REQUEST

Current Zoning: I-1 (Light Industrial)
Proposed Zoning: I-2 (CD) (General Industrial, Conditional)

Approximately 9.1 acres located on Westinghouse Boulevard between Park Charlotte Boulevard and Quality Drive.

The petition proposes to allow limited I-2 uses with accessory outdoor storage on a site in the Steele Creek community currently occupied by an industrial use.

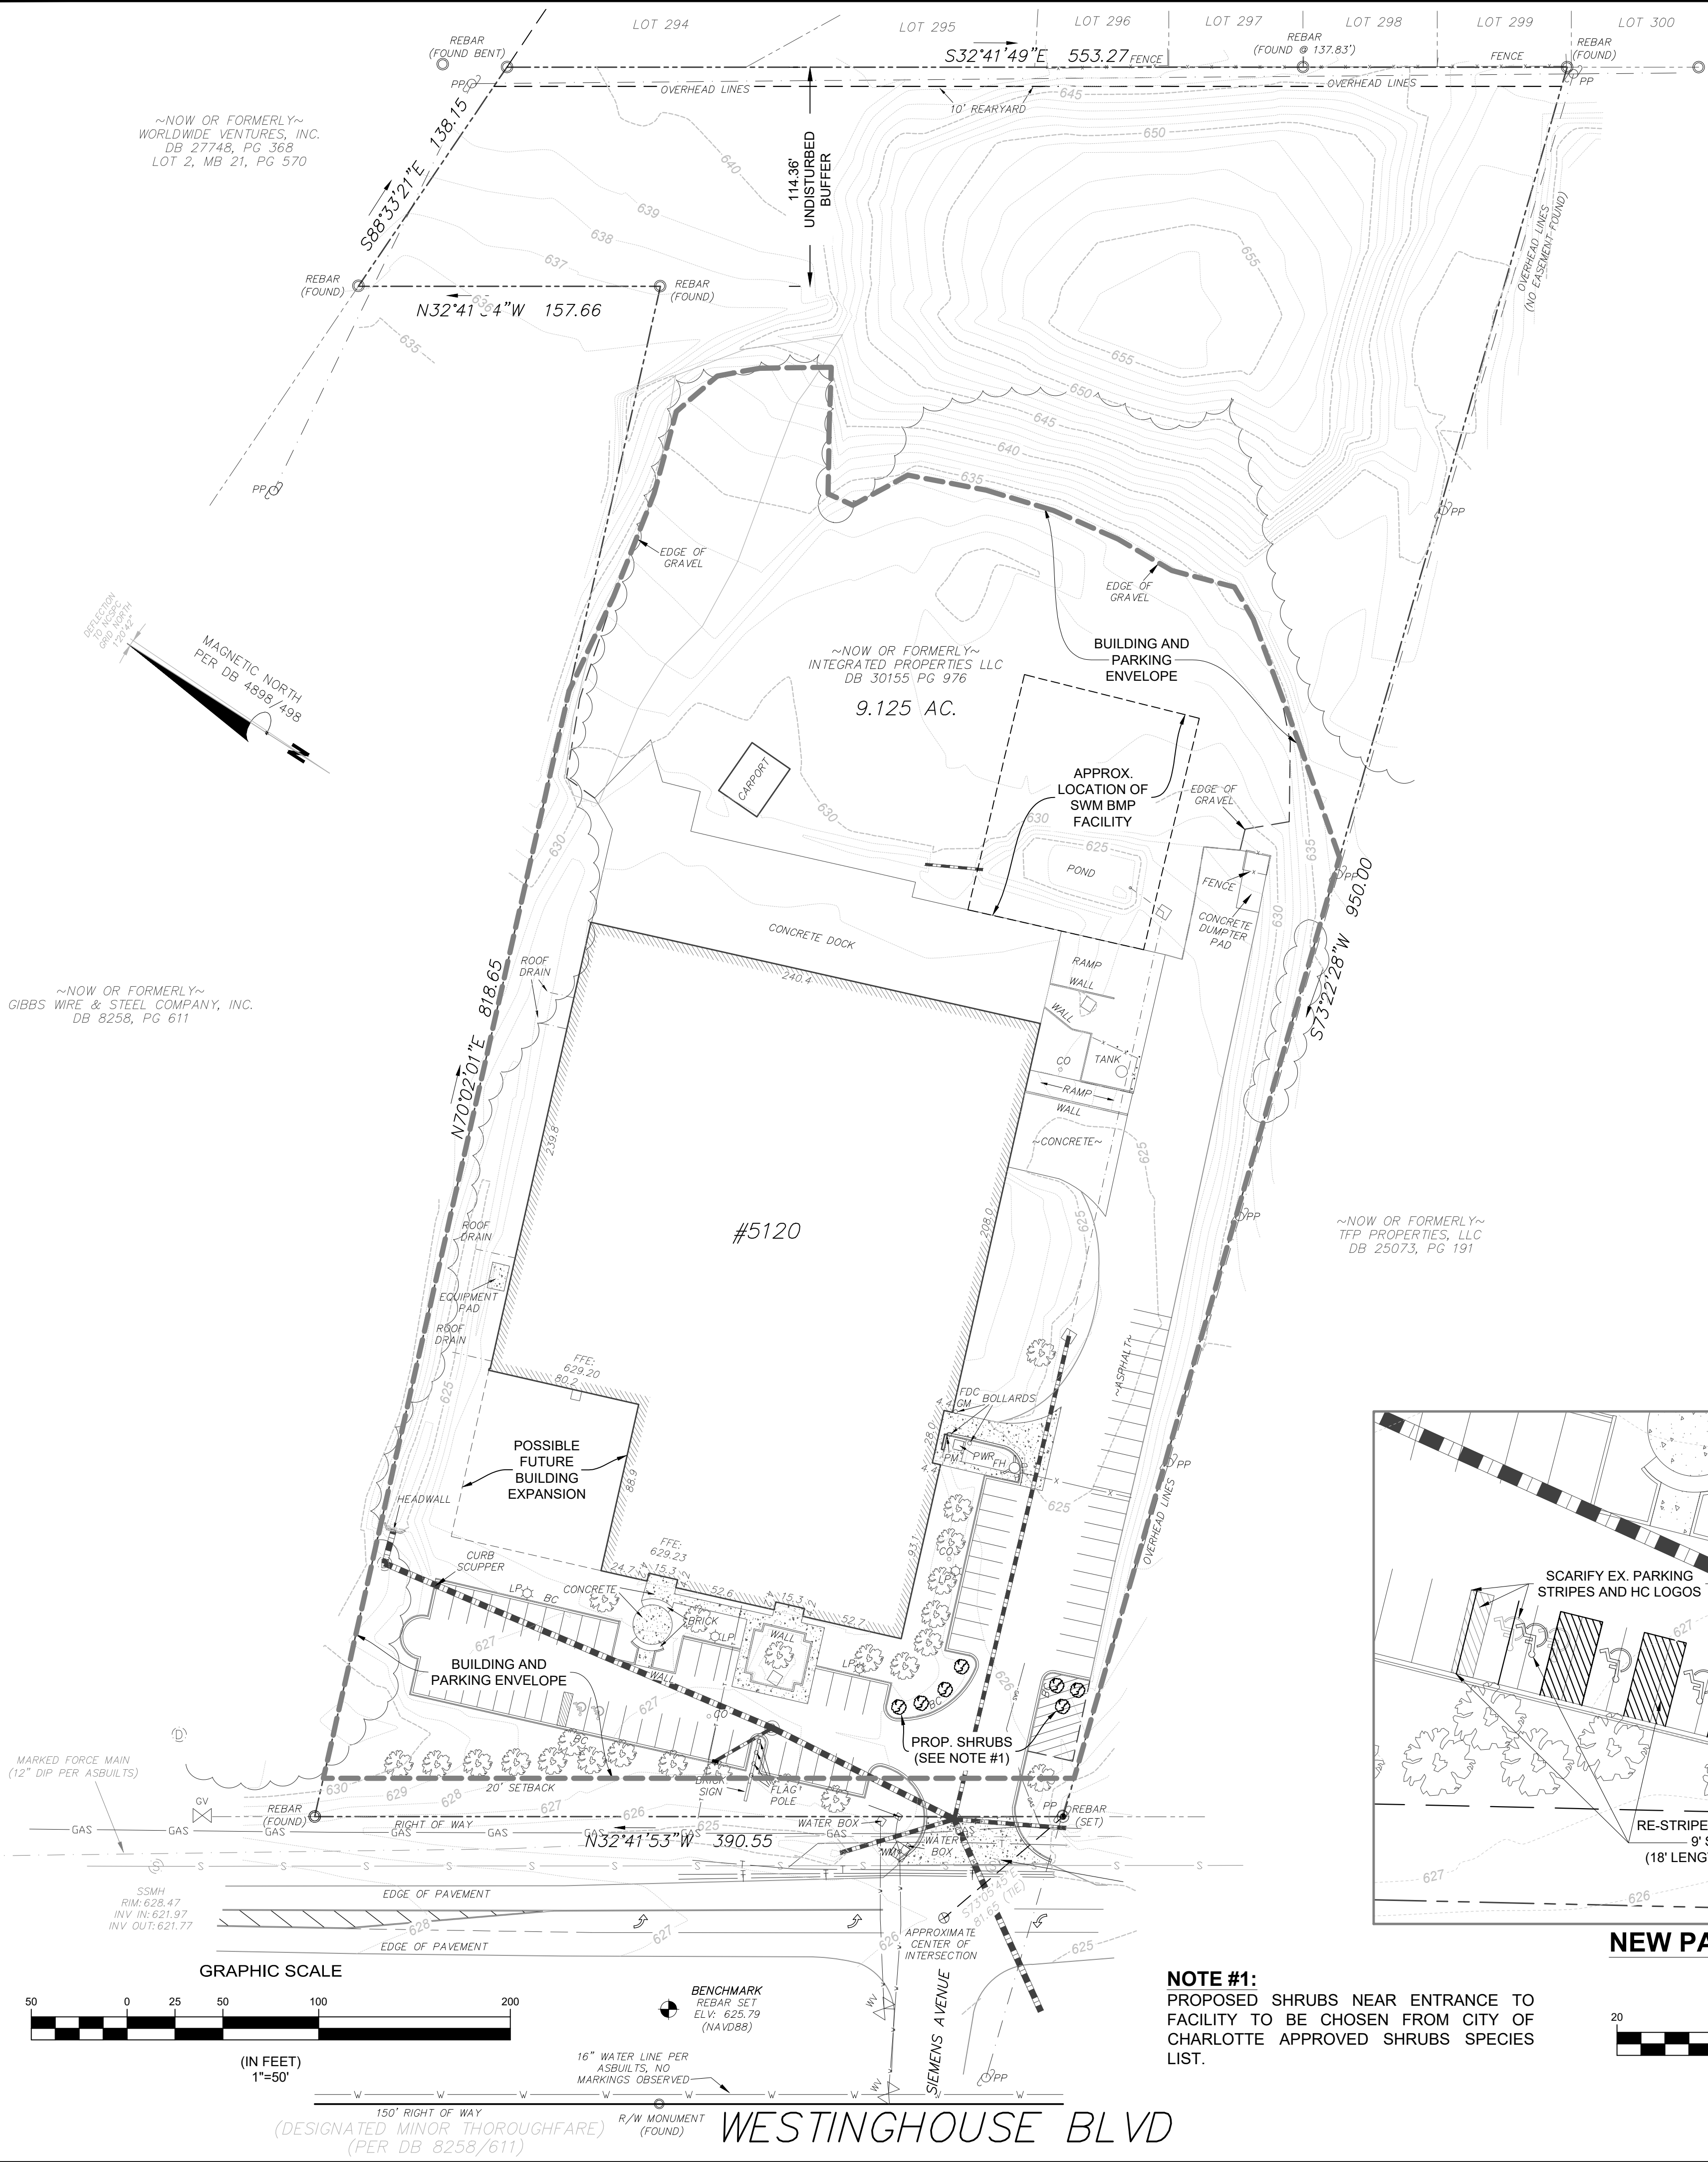
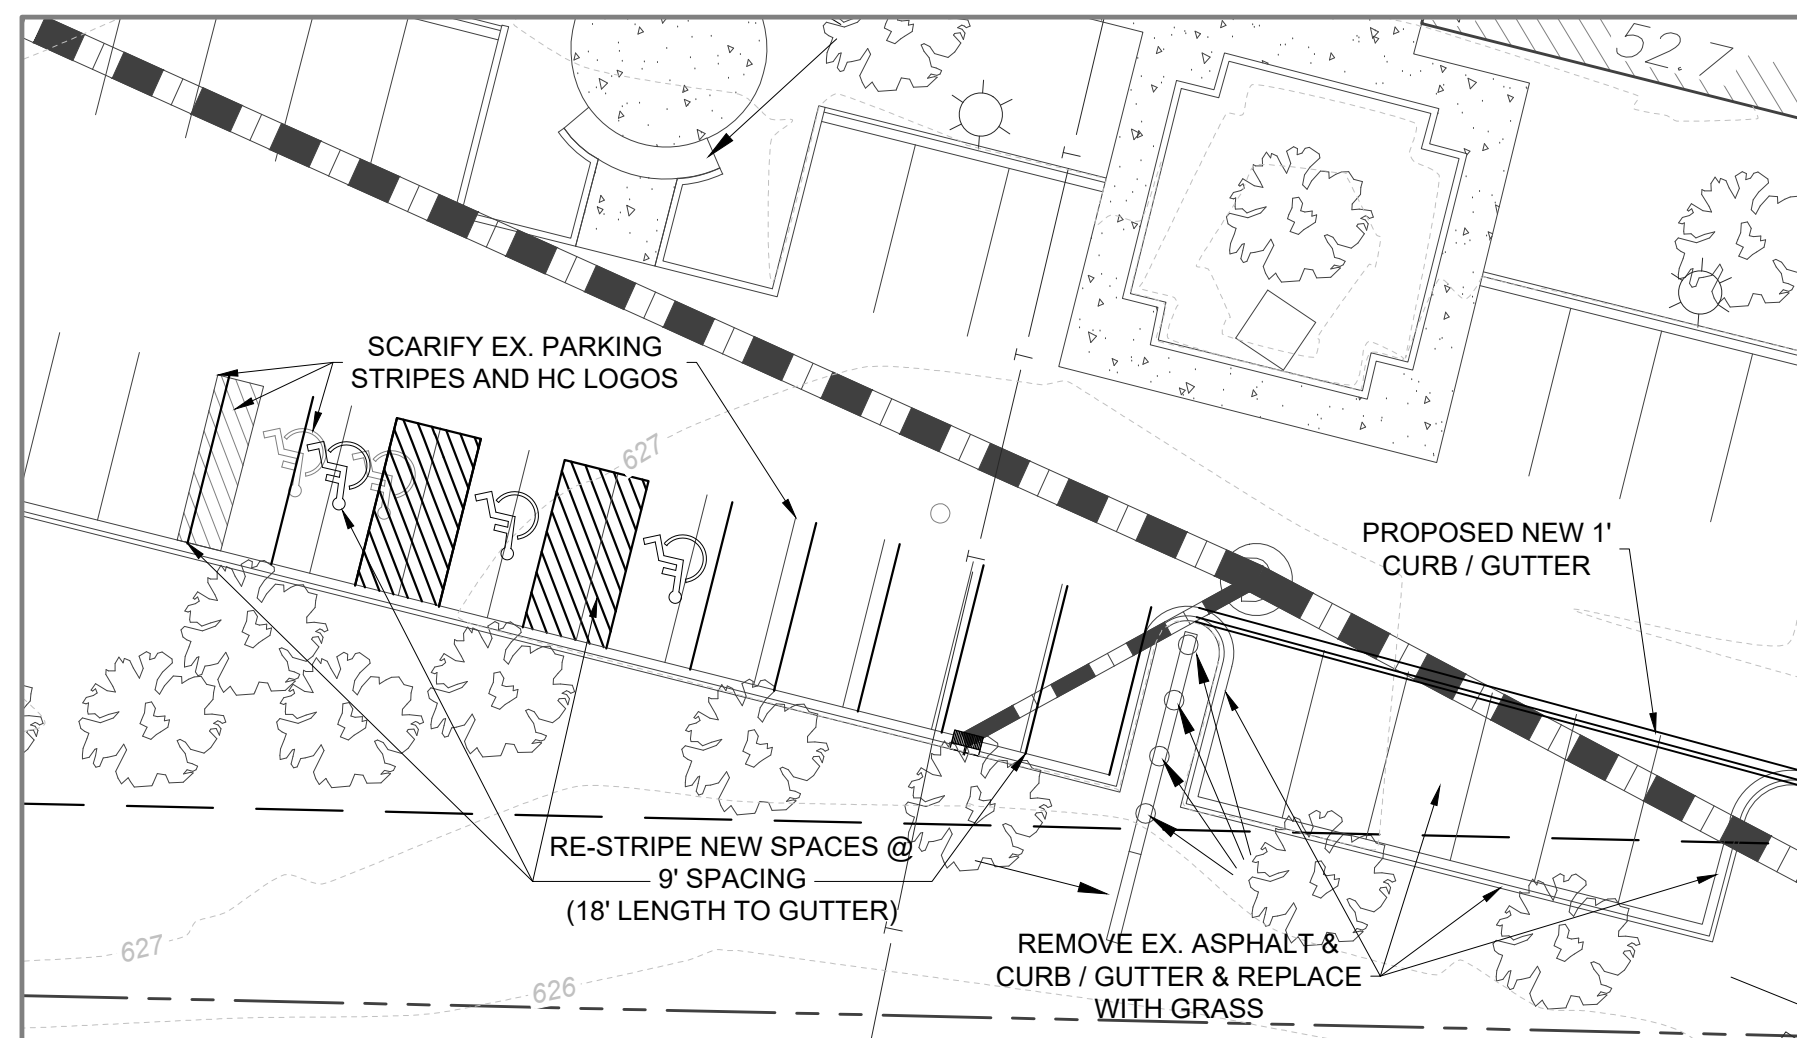
1. ~~Revise the site plan by labeling and dimension the curb line from the centerline to back of curb.~~ **ADDRESSED**
 2. ~~Revise the site plan by labeling the sidewalk and planting strip as "proposed".~~ **ADDRESSED**
 3. ~~Revise the site plan and conditional note 4.c by including a sidewalk utility easement placed 2-feet behind the proposed sidewalk.~~ **ADDRESSED**
 4. ~~Revise the site plan to ensure all future and proposed infrastructure, and all linework, is correctly oriented from the existing centerline of Westinghouse Boulevard.~~ **ADDRESSED**
 5. ~~Review and revise the verbiage of conditional note 4.d for accuracy.~~ **ADDRESSED**
- Site and Building Design
6. ~~Label parking in the setback as existing if it reflects current conditions. No new parking can be established in the setback.~~ **ADDRESSED**
